**From:** Contact Centre (CRM) <contact@ribblevalley.gov.uk>  
**Sent:** 28 June 2022 12:48  
**To:** Planning  
**Subject:** Planning Application Comments - 3/2022/0406 FS-Case-432880870

**Planning Application Reference No.:** 3/2022/0406

**Address of Development:** Land off Preston Road Ribchester PR33XL

Proposed Building ELEVATIONS

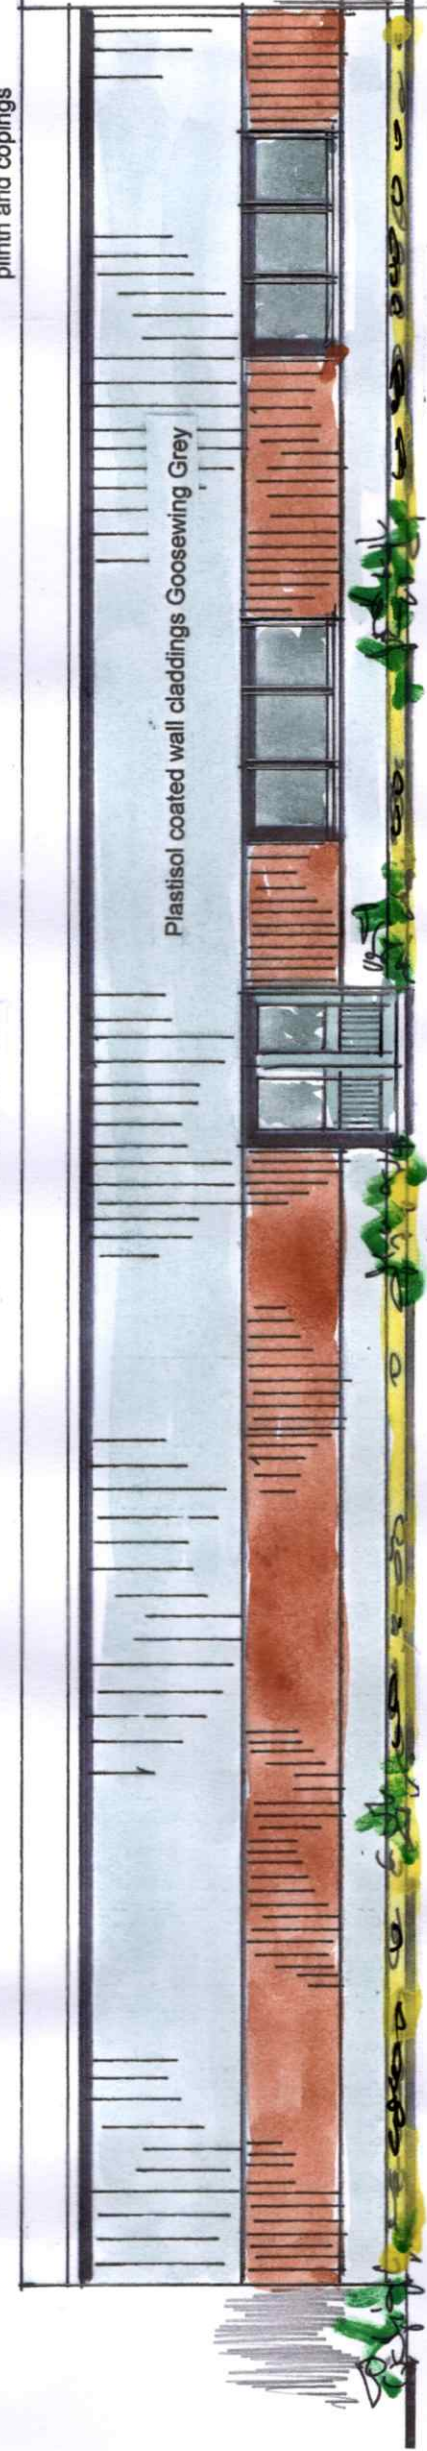
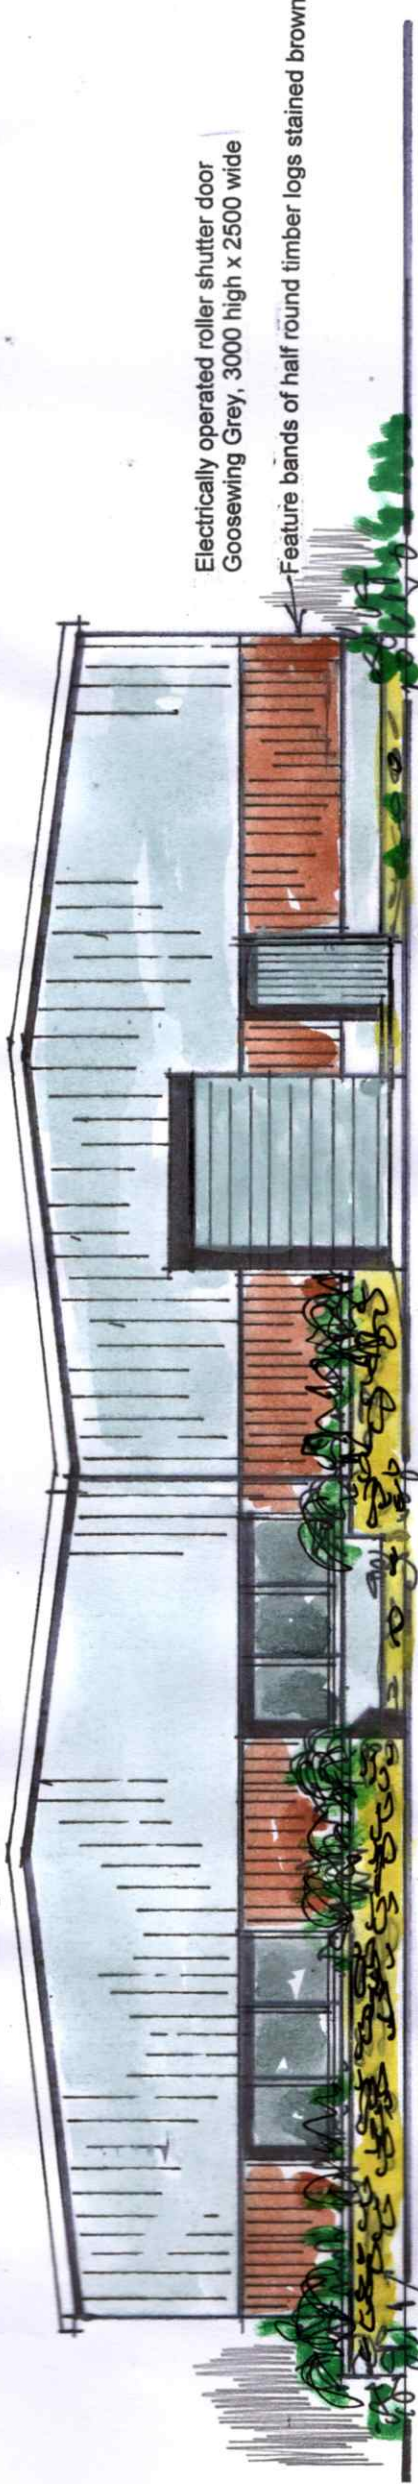
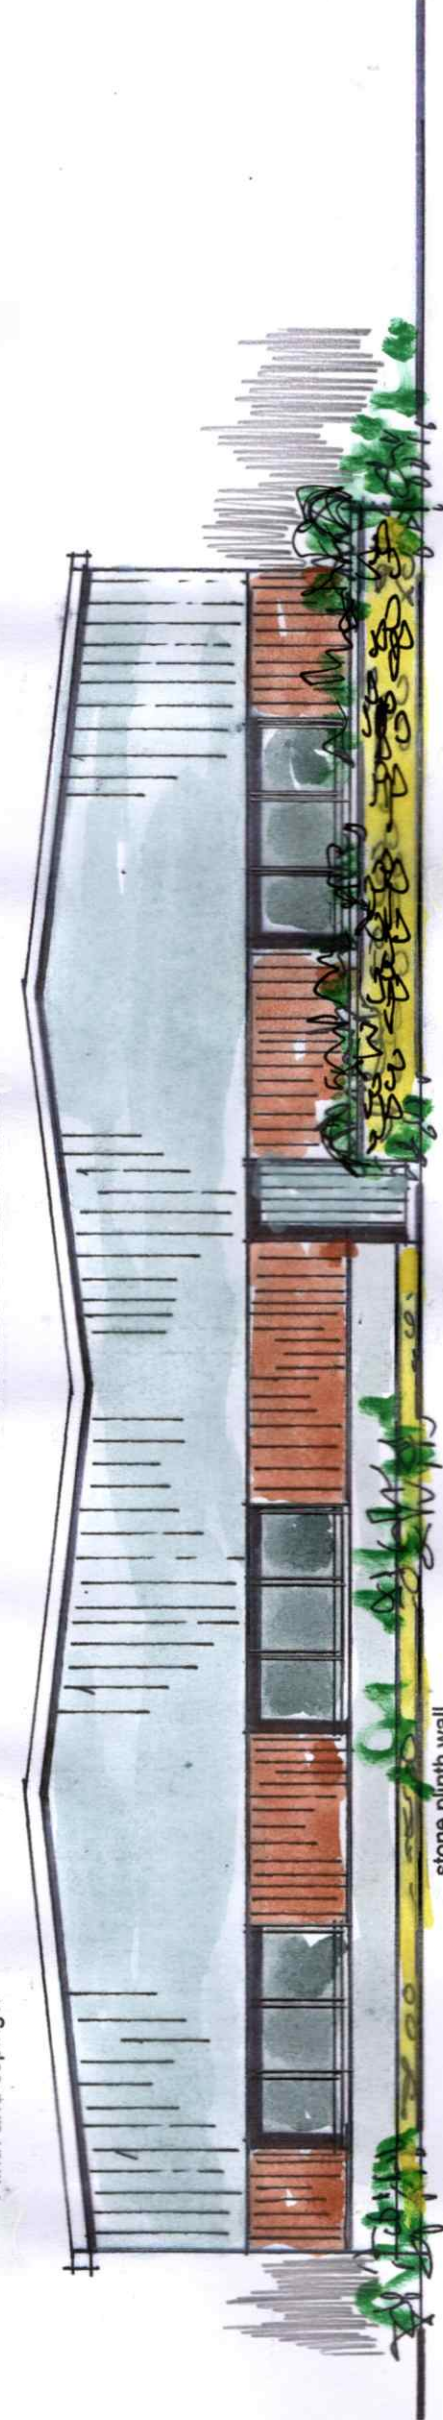
**Comments:** The applicant has proposed changes to external material for the large portal framed building in which he indicates that he proposed to breed snails. I do not believe that the proposed changes should be allowed as they are incongruous to the setting and not in keeping with the environment. The proposed changes to cladding would result in the building being covered in grey plastic resulting in approximately 2/3 to 3/4 of the visible building being industrial grey. The proposed external doors, windows and very large roller shutters are also proposed to be grey adding to the industrial appearance of the building not in keeping with the area. Similar changes to the external appearance have been refused by the council and the resubmission makes little difference to the overall appearance previously refused. I would question also the need for a 3 meter high roller shutter as nothing similar appeared in original application. I would also comment the drawings presented are not to scale and therefore give a very different view of the proposed building than in face of the case. The height of the building actually built is not accurately reflected in the drawings submitted.

The internal and external elevations presented are confusing and do not appear to correspond to one another for example the elevation showing the roller shutter indicates windows no such windows are shown on the internal layout plans. When taking account of the roller shutter measurements it would appear that vehicles will enter directly into the breeding and hibernation units - is this accurate. Staff showers and caging areas appear to have been replaced by offices. Overall plans are very confusing and I question why the developer can not be more accurate in his representations of the buildings.

**Proposed Development**  
**SITE LAYOUT**

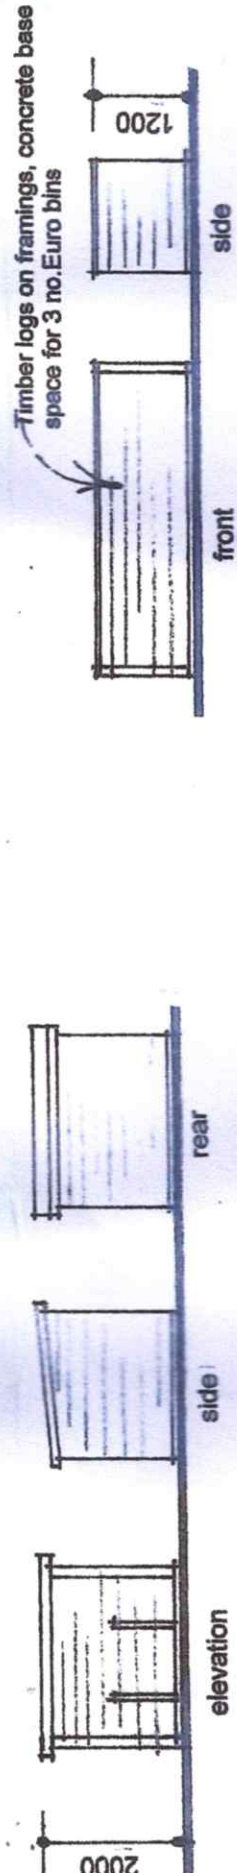
I note that the revised plans reposition the "holiday cabins" back to their original location, a move refused by the planning committee in the last variation of planning application made by [REDACTED]. It should be noted however on the site 2 run down tatty porta cabins have been placed in the location of bases built in locations previously refused by the planning committee. These portacabins being previously sited for a considerable number of years at the applicant's land in Grimsargh and more recently led to the site. They are an eyesore, not in keeping.
